Please register the statement below as an objection to the application listed under the reference M/28/20/DOC. This is in lieu of a paper submission, receipt of which cannot be guaranteed in the current situation. I request that the content be considered and that it be uploaded onto the planning portal.

I am writing to register an objection to the application made under reference M/28/20/DOC, regarding proposed drainage work at the former Yapton Poultry Farm.

Figure 1
Groundwater Level at all Boreholes

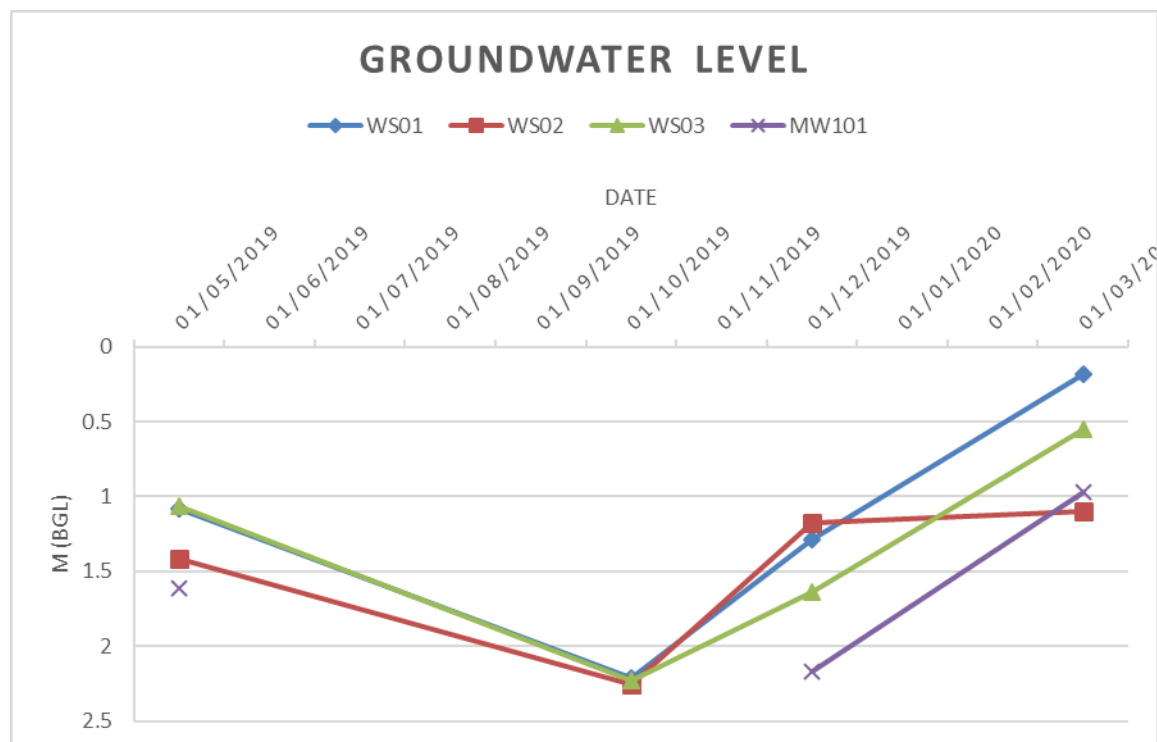
4. Turning to the report itself, Figure 2-1 shows ground water levels measured over time at just one of the three sites referred to in table 2-1 (WS02). It is notable from table 2-1 that this is the site that recorded the greatest depth of water below ground level, and hence indicates the least chance of flooding. Why are there no graphs for sites WS01 and WS03? Surely, with a higher starting point these would have recorded higher peak water levels (ie closer to ground level) than the bore hole WD02. Again, why is the data from these sites not referred to? Moreover, no information can be found in the report regarding the locations and actual ground level datum for the sample points. This effectively renders the data meaningless, and suggests an attempt to cherry pick data to conceal the fact that the ground water issue is far more significant than represented.

Given that the development site sits about 0.5 metres above road level, water at the levels indicated by the graph would flow into the road and exacerbate local flooding of the highway and nearby property. A low bund is suggested as a solution, but experience suggests that water flows around such devices, and therefore this solution would not prevent flooding onto the Yapton Road and beyond.
